**2023/0329**

Side and rear extensions with rooms in roof and new front boundary wall

Three Ways, Near Cotes, Thurgoland, Sheffield, Yorkshire, S36 8YB

Drawing Title: Elevations - PROPOSED

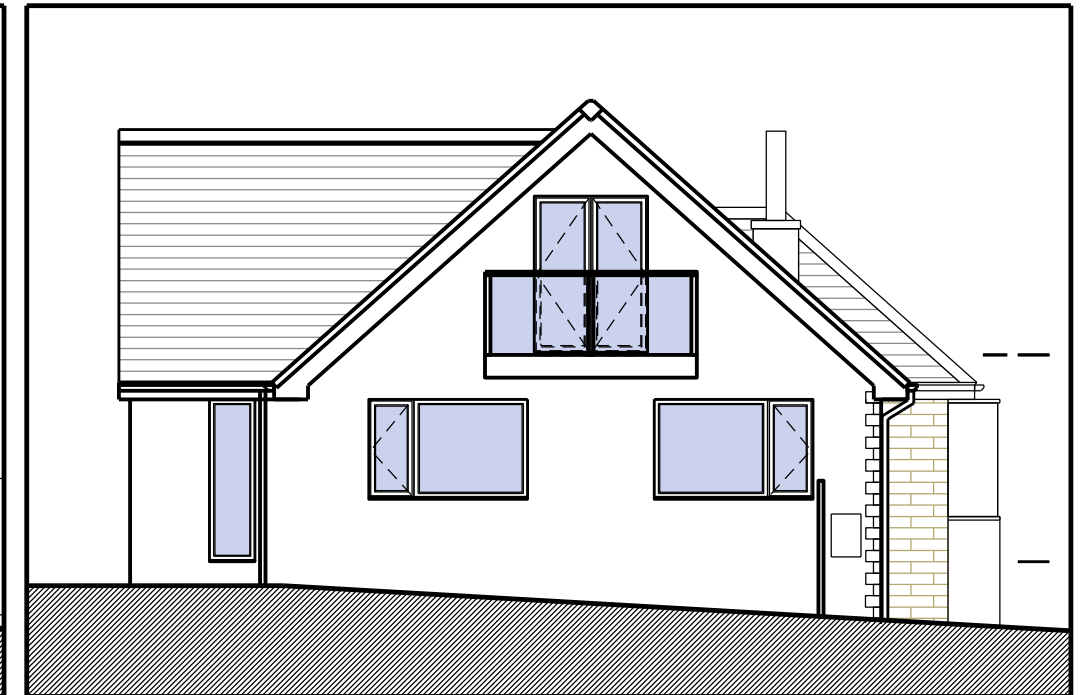
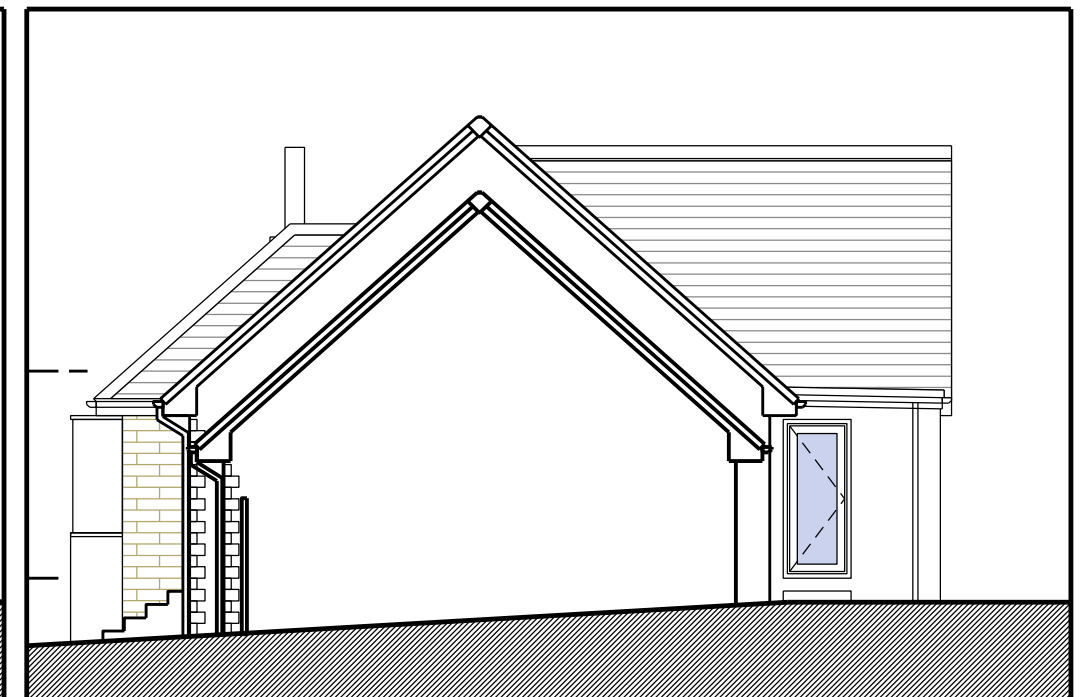
The SPD states that side extensions should normally be designed with a set back from the front elevation and a corresponding lowered roofline. In addition extensions should not exceed 2/3rds of the width of the original dwelling. The proposed garage extension is designed with a lowered roofline and a set back, and as such, would appear subservient to the main dwelling. The proposed side extension with rooms within the roof space has not been designed with a lowered roof or a set back, however as this is an individually designed dwelling, with a front and rear projecting gable, it is felt that the side extension would not appear dominant and would appear as part of the original dwelling once constructed. The extension does not exceed 2/3rds of the width of the original dwelling.

Roadside wall elevation

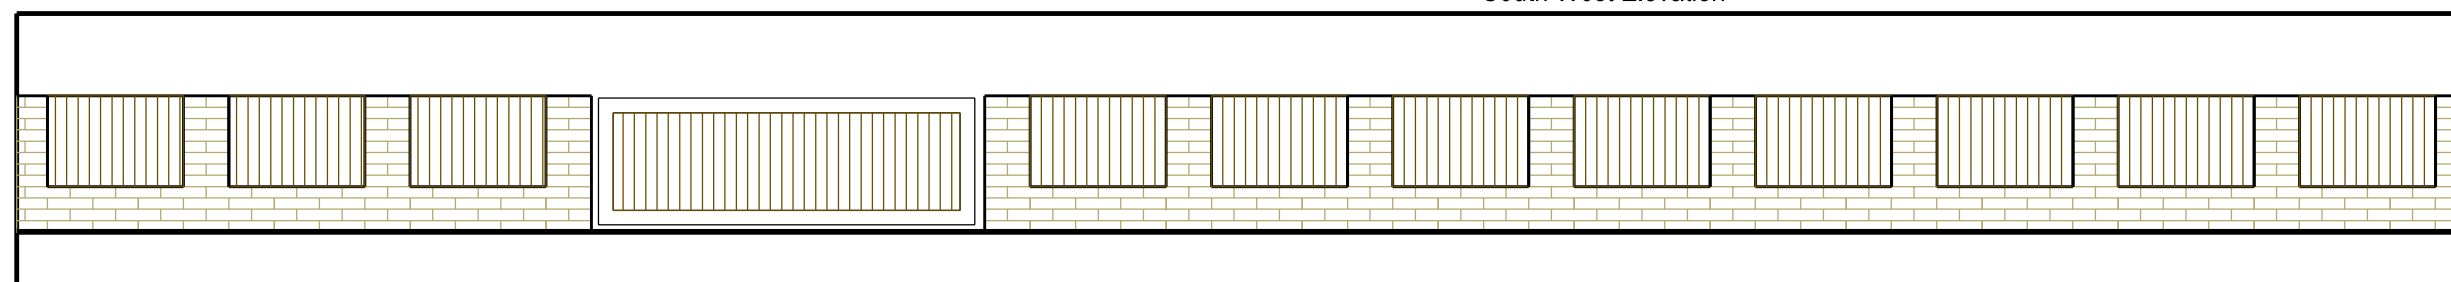
The proposal also includes the erection of a new fence/wall up to a height of 1.8m along the front boundary. The current dry stone wall appears to be less than 1m in height and will be removed and replaced as part of the proposal. The design of the wall/fence is as such that the stone wall appears of a similar height to the existing with pillars and fence panels to break up the bulk visually.

The proposed wall/fence is set back from the highway by approximately 2m – 2.5m and the proposed gates set back 5m into the site. The proposed wall would be 0.8m higher than what is normally allowed under permitted development rights, which is not significant given that the wall/fence is set back from the road, in addition, there is a stone wall set further down Coates Lane which is in excess of 1m in height which has set a precedent for walls of this nature adjacent to the highway. The proposal is therefore acceptable in terms of visual amenity in accordance with policy GB2 of the Local Plan and the House Extension SPD.

The proposals include ample parking and turning provision within the site. It is proposed to erect a 1.8m high boundary wall/fence along the property frontage, however given that the gate is set back 5m into the site and the access has a width of approx. 5m, pedestrian visibility splays are not compromised by the proposed wall height.

Site Plans - PROPOSED

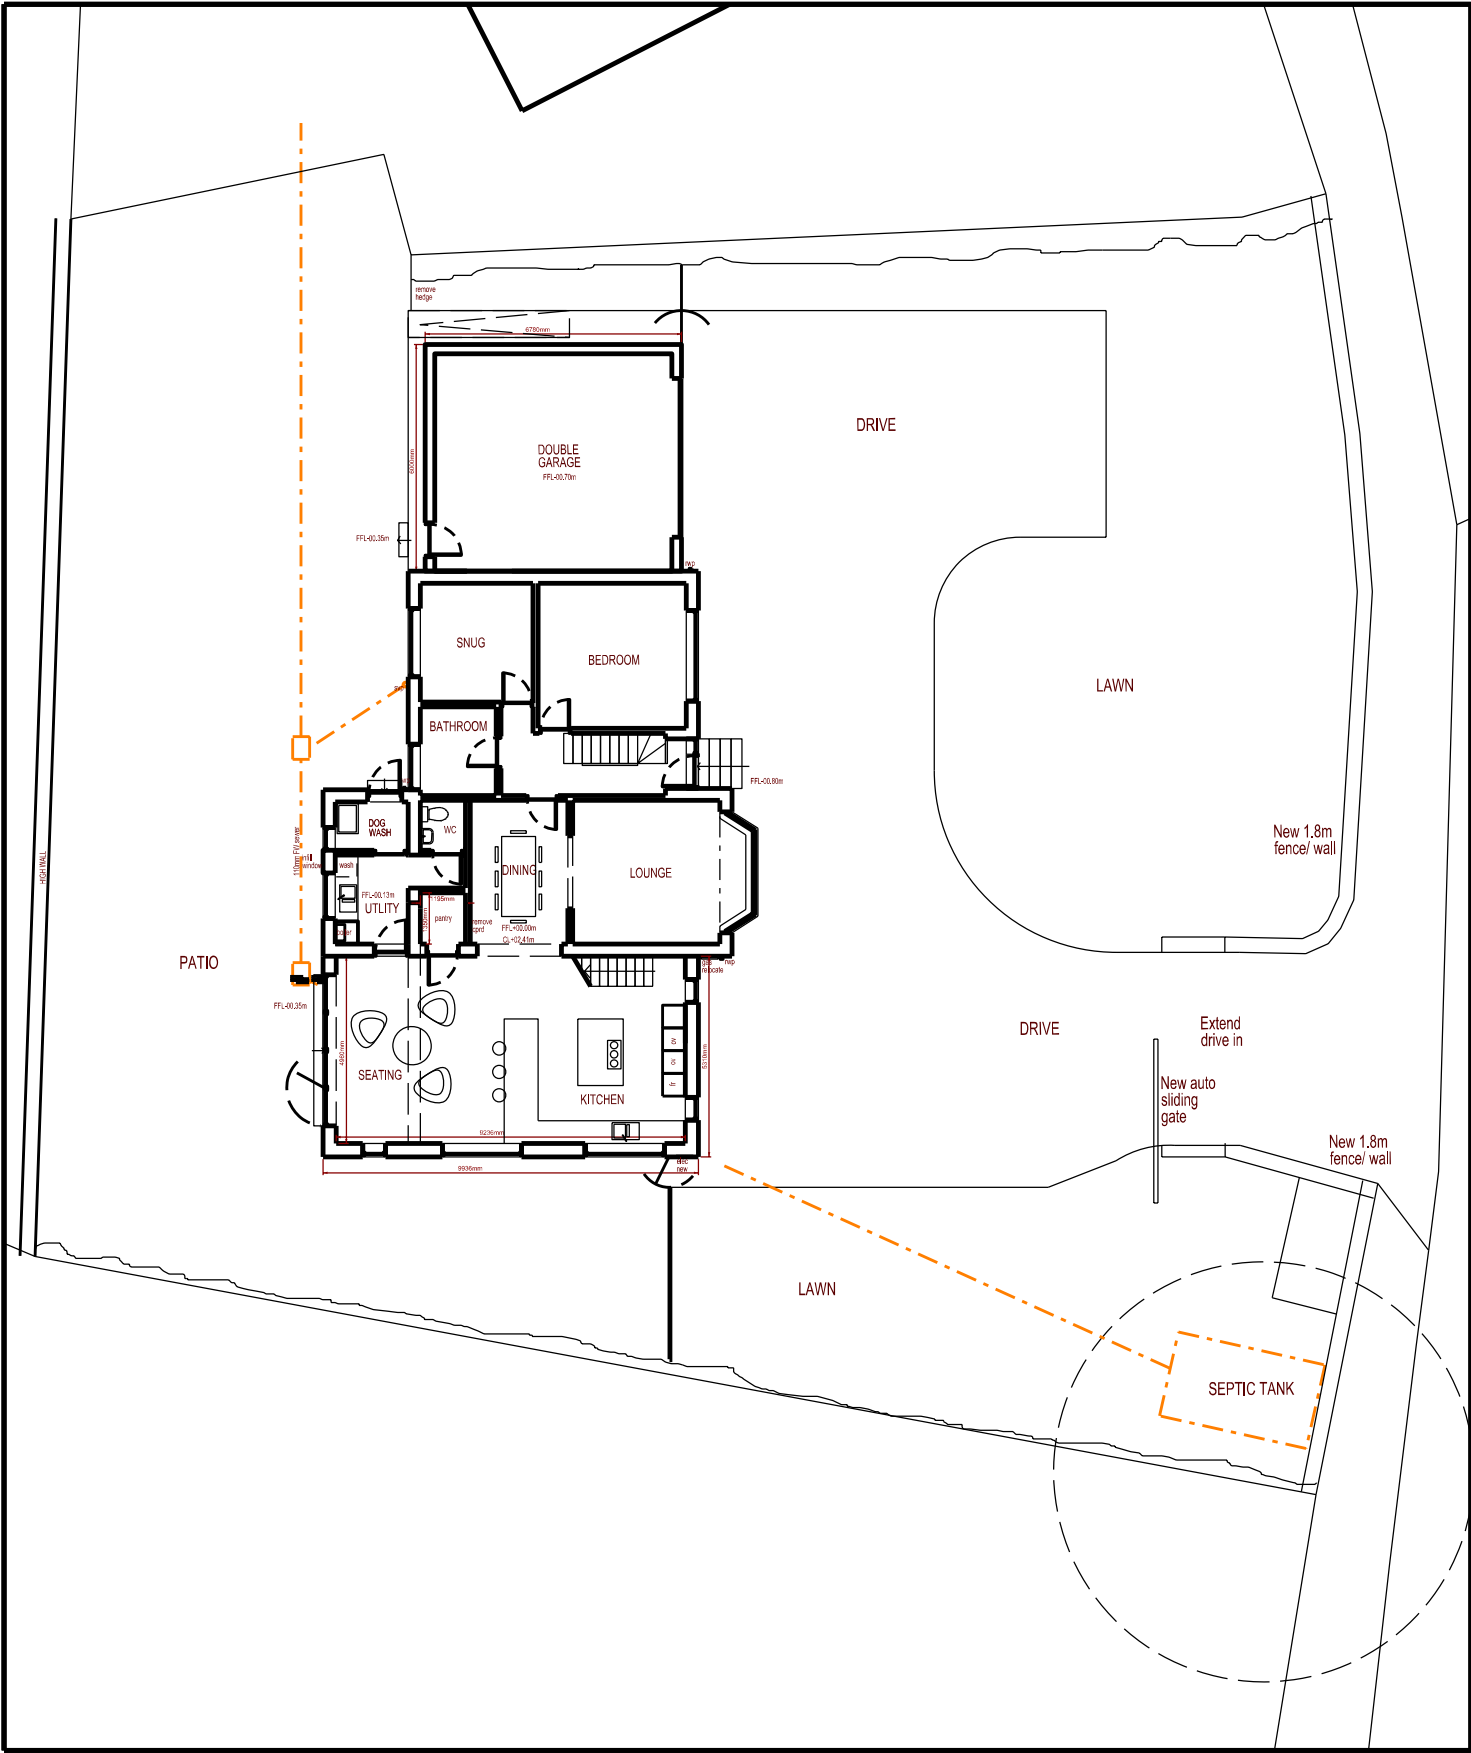
The property is situated to the south east of Brontella. An objection has been received from the occupiers of Brontella with regard to an overbearing and overshadowing impact and access issues with regard to this garage. The proposed garage which runs along this side of the property has now been reduced in size and is now a sufficient distance of 8m away from the side elevation of Brontella as to not cause any impact upon their residential amenity by way of overshadowing, overbearing impact or loss of light from the proposed garage. There are no windows in the side elevation facing Brontella, therefore no overlooking will occur. There are no properties to the south east of the applicant's dwelling.
